Project Special Provisions
(Version 06.5)
Signals and Intelligent Transportation Systems

1. 2006 STANDARD SPECIFICATIONS FOR ROADS & STRUCTURES

The 2006 Standard Specifications are revised as follows:

ENGLISH DETAIL DRAWING FOR  
**INDUCTIVE DETECTION LOOPS**

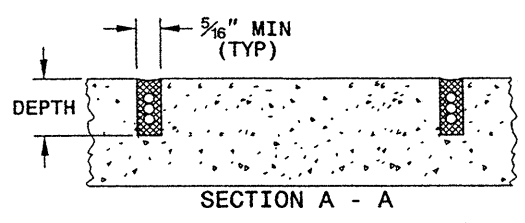
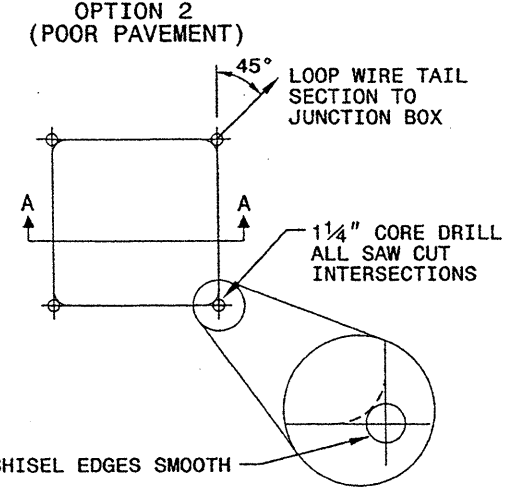
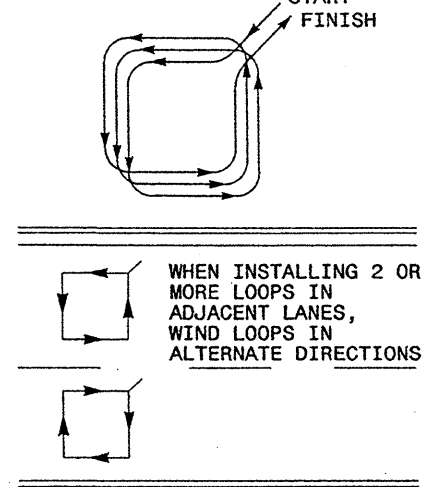
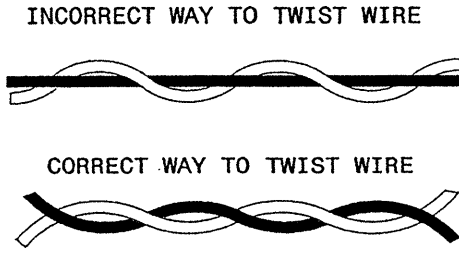
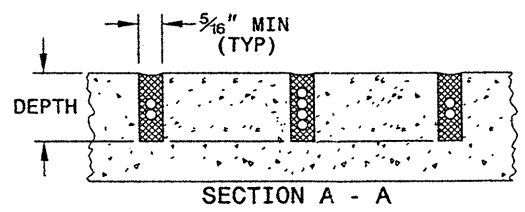
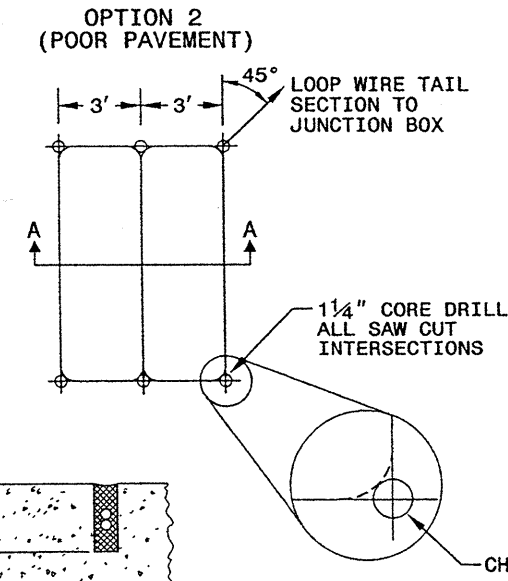
"Twist loop conductor pairs a minimum of 5 turns per foot from where conductors leave saw slot to junction box.
